# CITY OF ALBUQUERQUE

**Re: Old Dominion Freight Line,  
330 Airport Rd NW  
Request for Permanent C.O. –Accepted  
Engineer's Stamp dated: 3-27-13, (K10D008A)  
Certification dated: 11-05-13**

**File: K10D008A**

Sheet Name:  
GRADING AND DRAINAGE PLAN

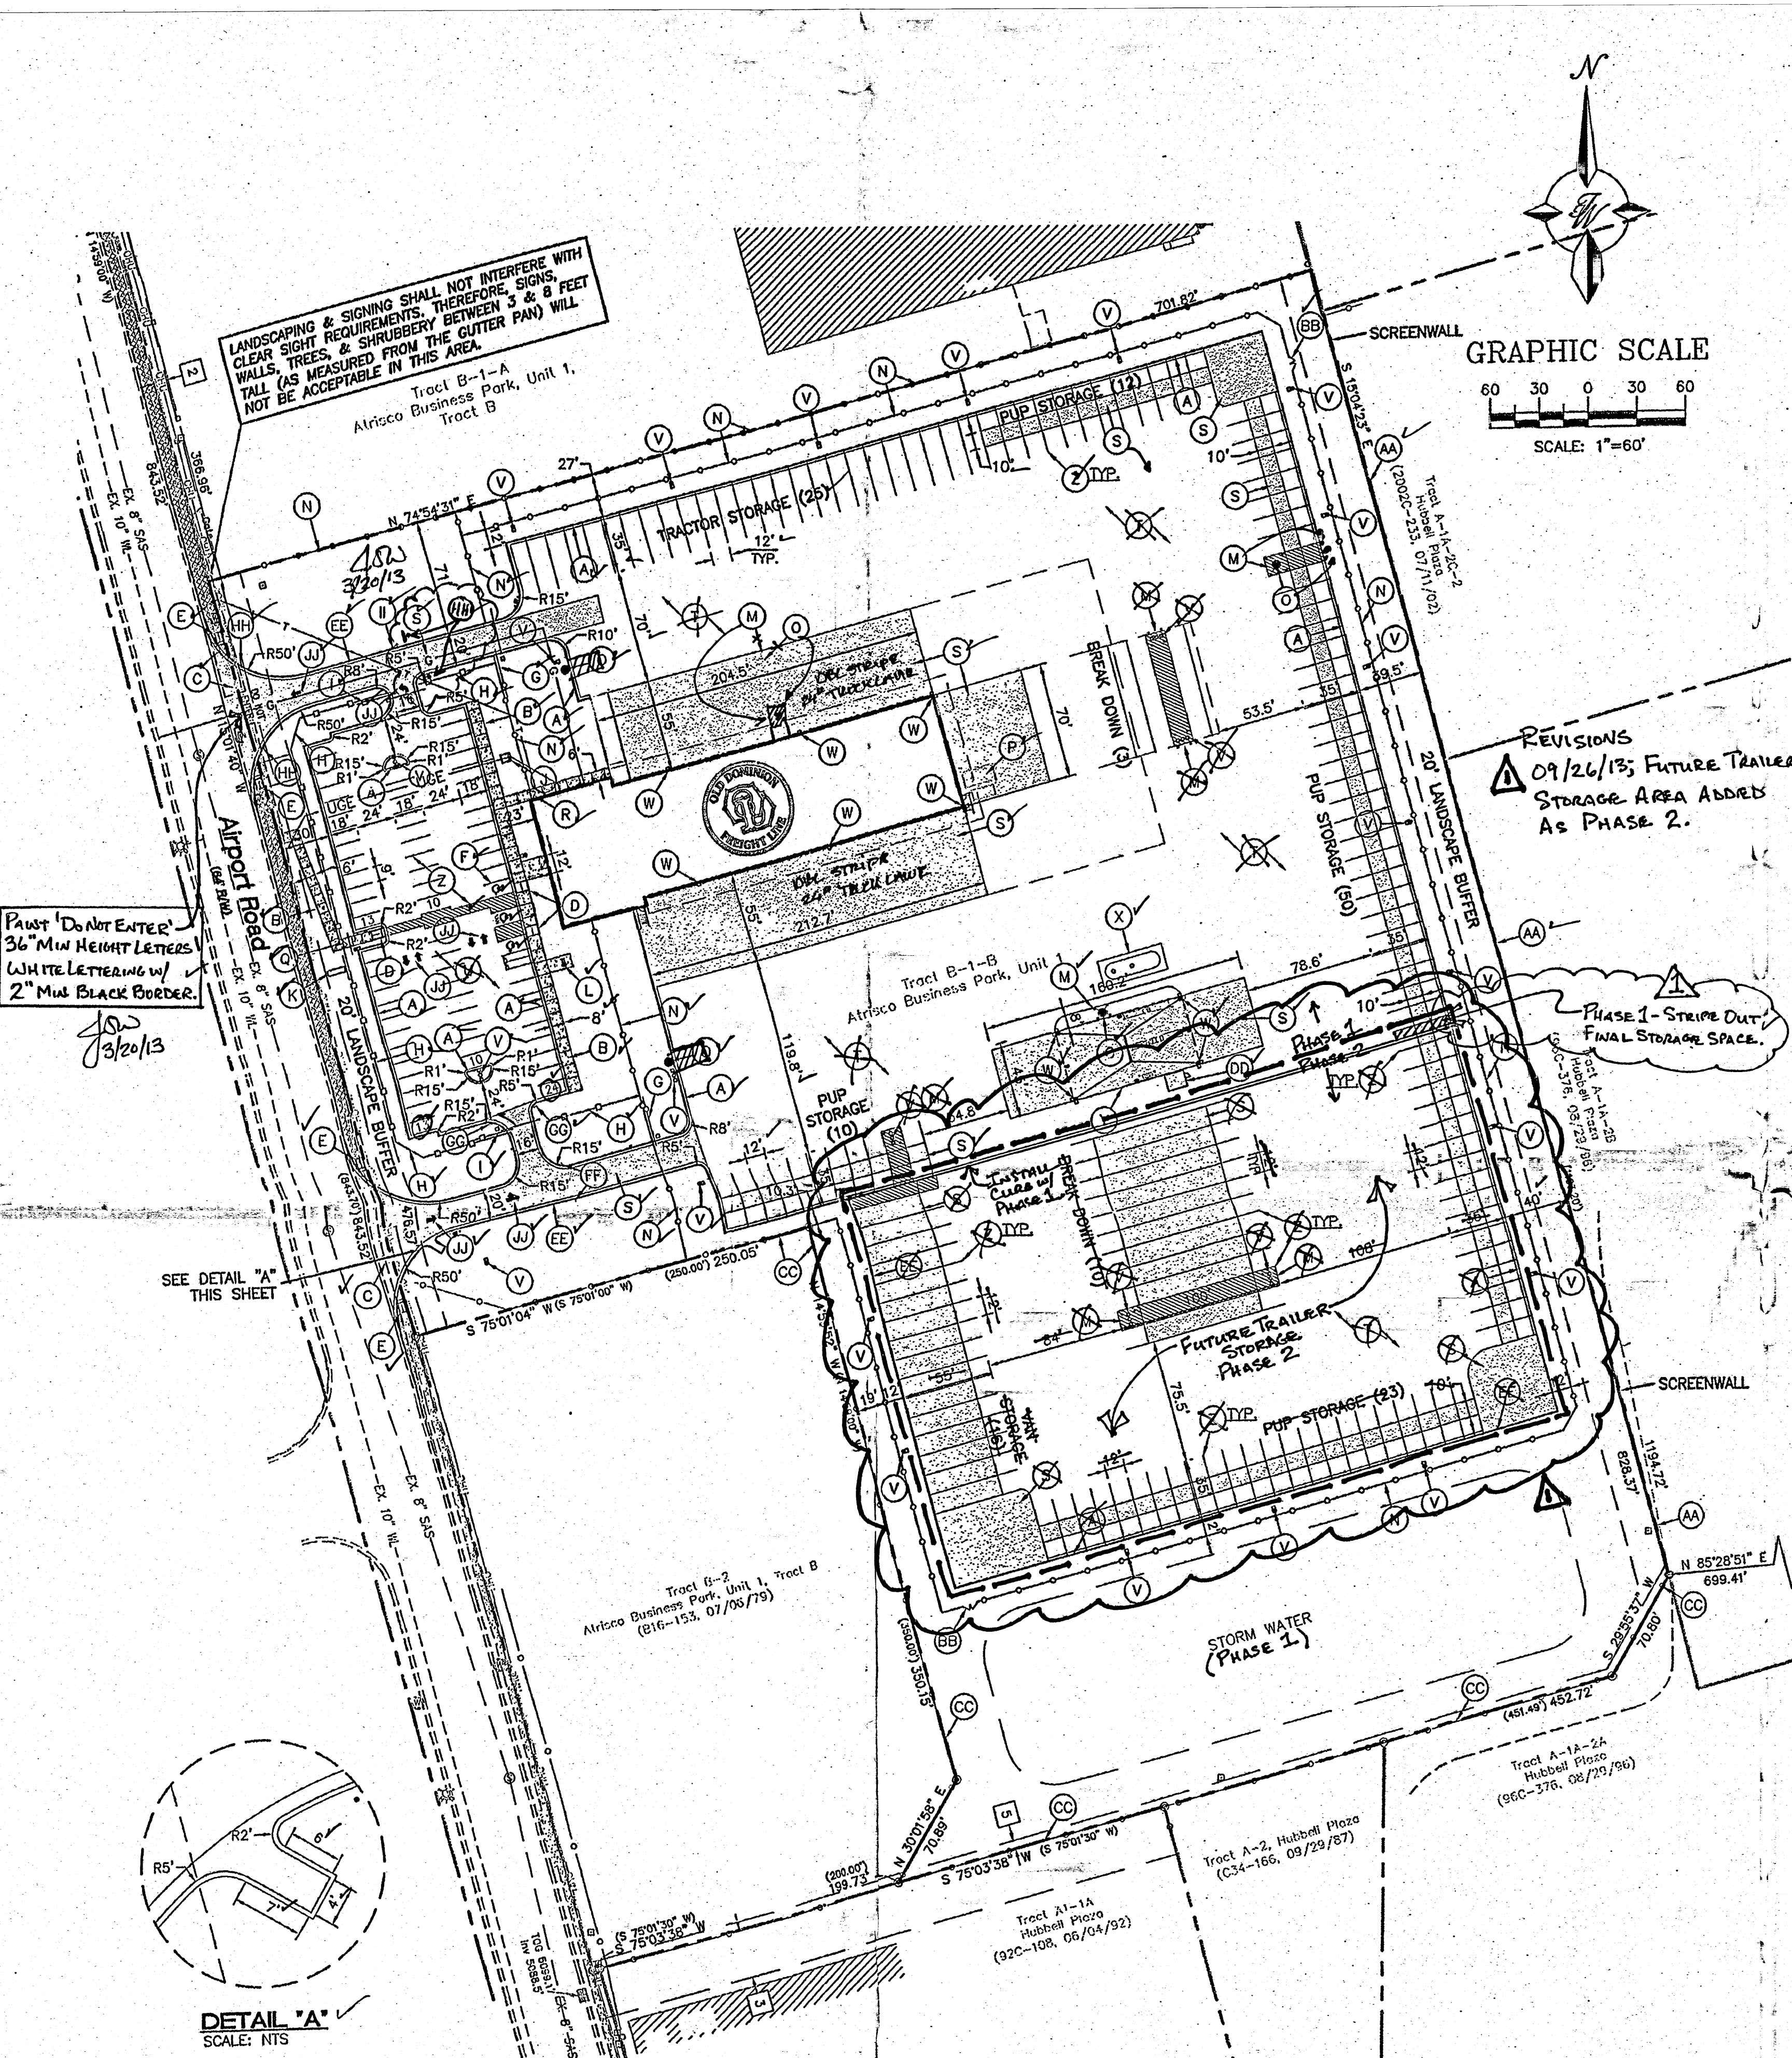
1. The Phase 1 Curb along the south edge of the paving was shown on your 10/16 plan, but not on this plan. I would like you to annotate our file copy of the plan and initial the change to show this as-built condition.

2/ Similarly, the Rip-rap outfall at the south end of the east swale needs to be shown, dimensioned, annotated and initialed.
